2.303 PERMIT APPLICATION

The Northern Delivery System (NDS) is proposed to bring renewable water to Northern El Paso County municipal customers. The existing Southern Delivery System infrastructure will be utilized to convey, treat, and deliver surface water to the north end of the Colorado Springs Utilities (Springs Utilities) service area at a location known as the SPRINGS UTILITIES Highway 83 Storage Tank. The proposed NDS project will convey water from the SPRINGS UTILITIES Highway 83 Storage Tank through a pump station and transmission main at which point it will be delivered to existing District storage for distribution to customers. The proposed facilities are located within the jurisdictional boundaries of both El Paso County (EPC) and the Town of Monument. The extent of El Paso County review is identified in the map included as Appendix A.

MHT-3
Detour Plan for Roller Coaster Road
Between Baptist Road and
Stagecoach Road

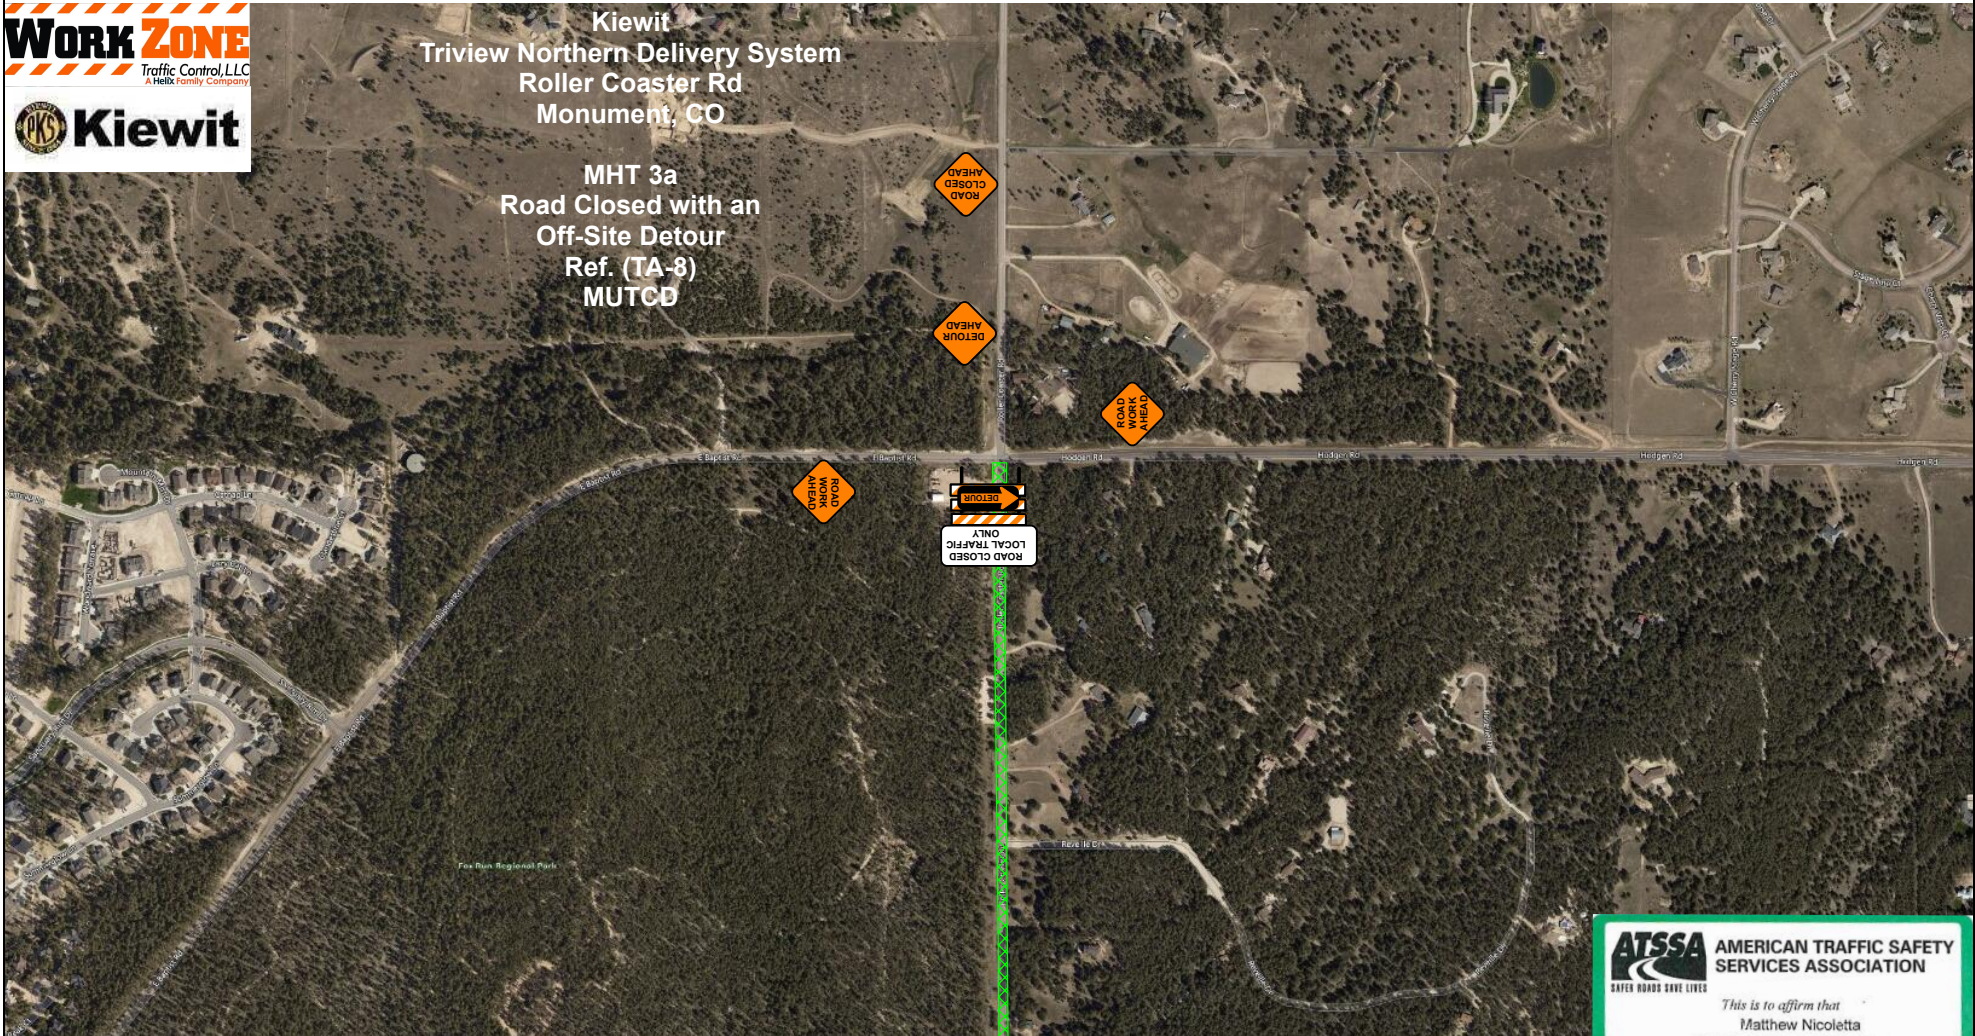
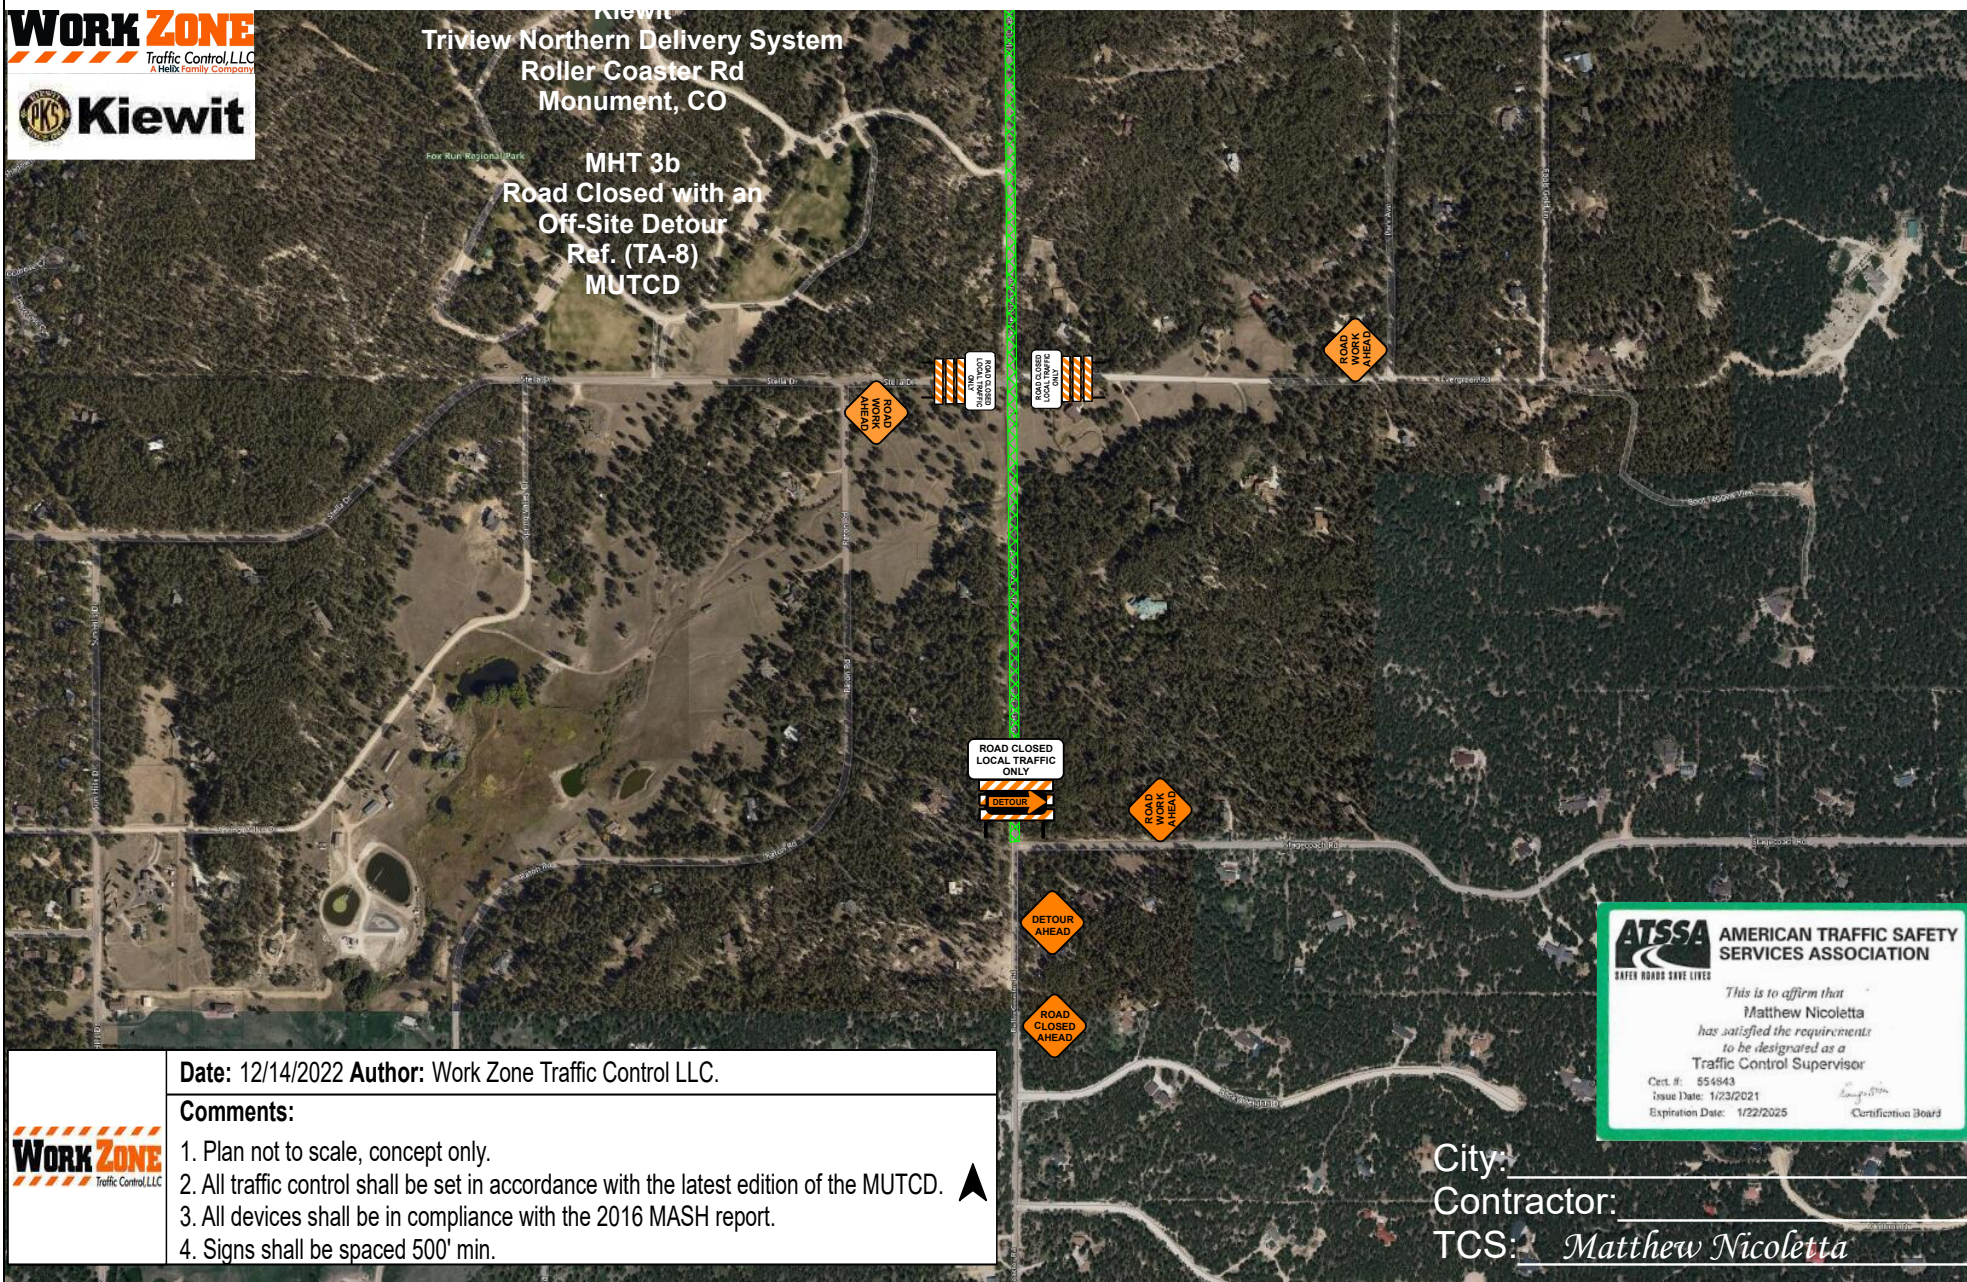
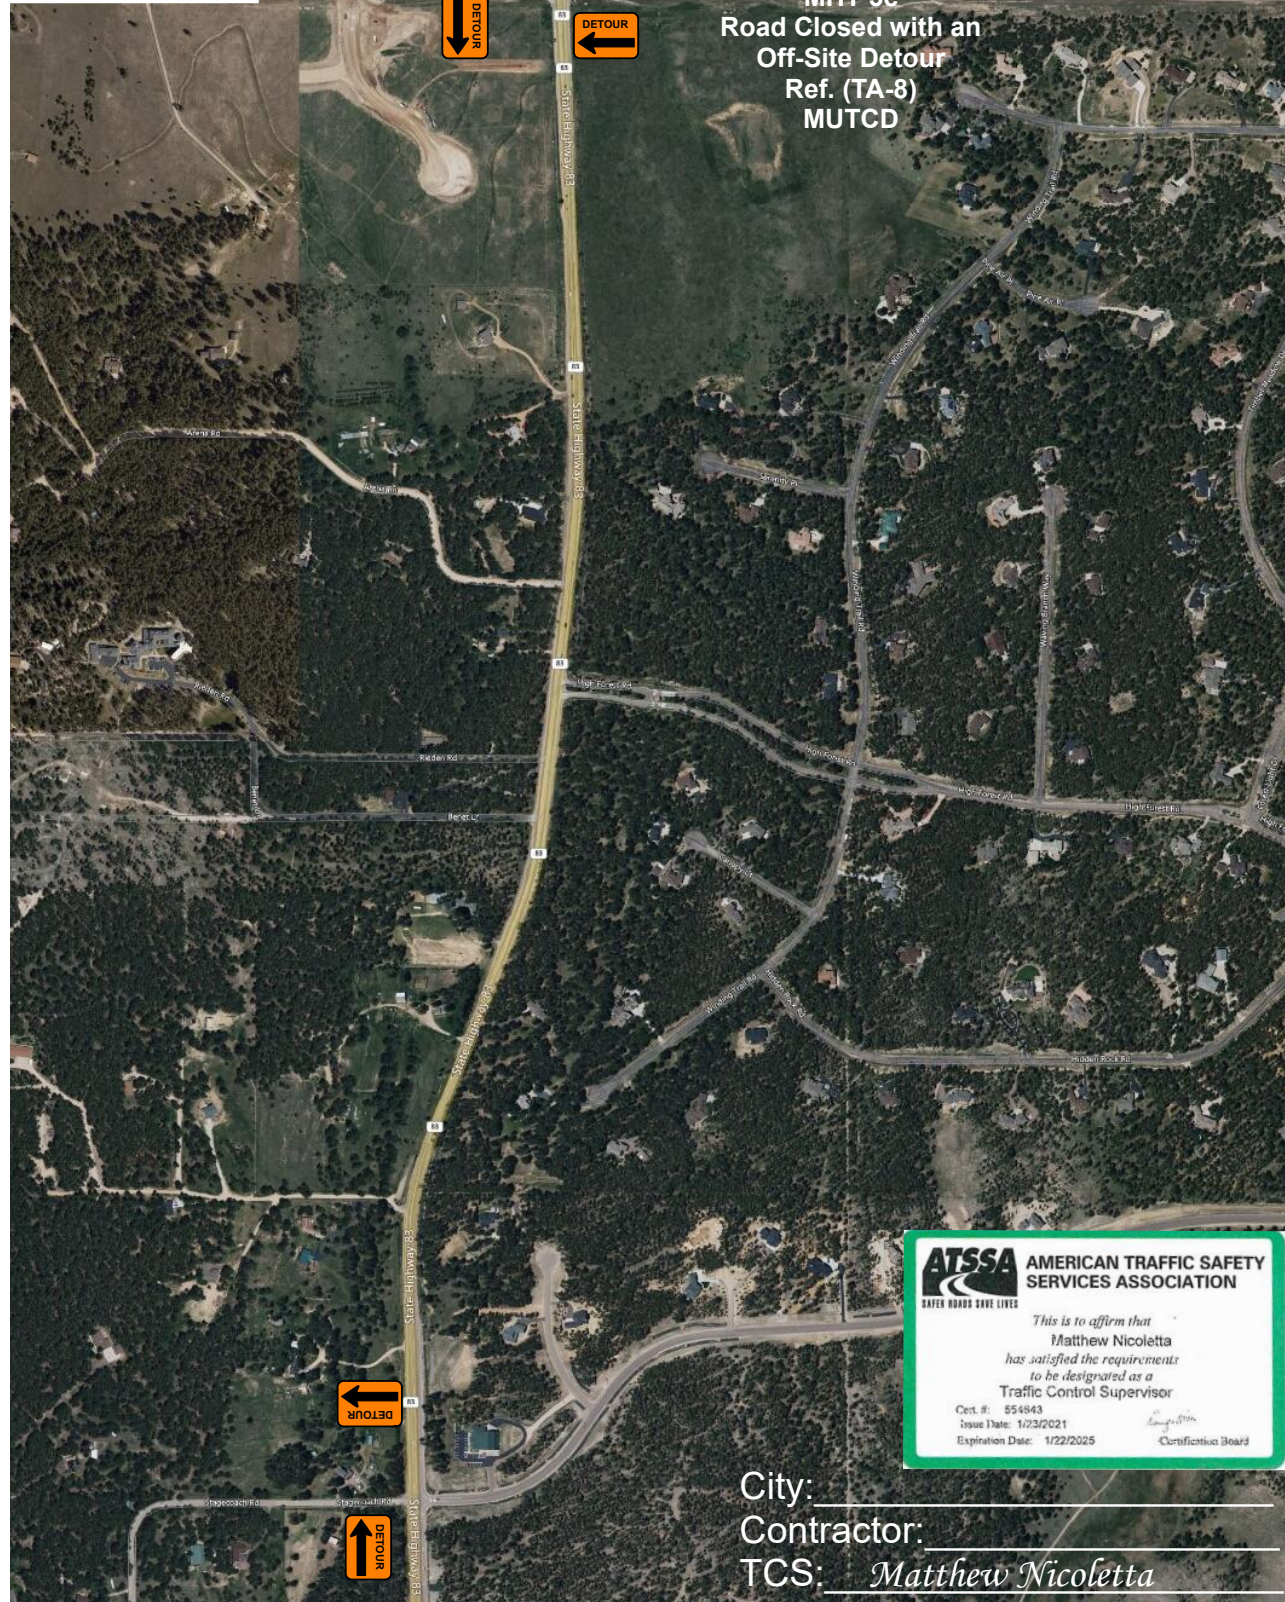
Noted.  **Detour Map and Detailed Construction**
Detour Map

- ← **detour maps provided to ensure safety of residents**
- (d) Descriptions of alternatives to the Project considered by the applicant. If the Director determines that the nature or extent of the proposal involves the potential for significant damage and warrants examination of other specific, less damaging alternatives, the Director may require the applicant to evaluate and present information on such additional alternatives as part of the application.

- (e) Schedules for designing, permitting, constructing and operating the Project, including the estimated life of the Project, **detour maps outlining schedule are appendix X**
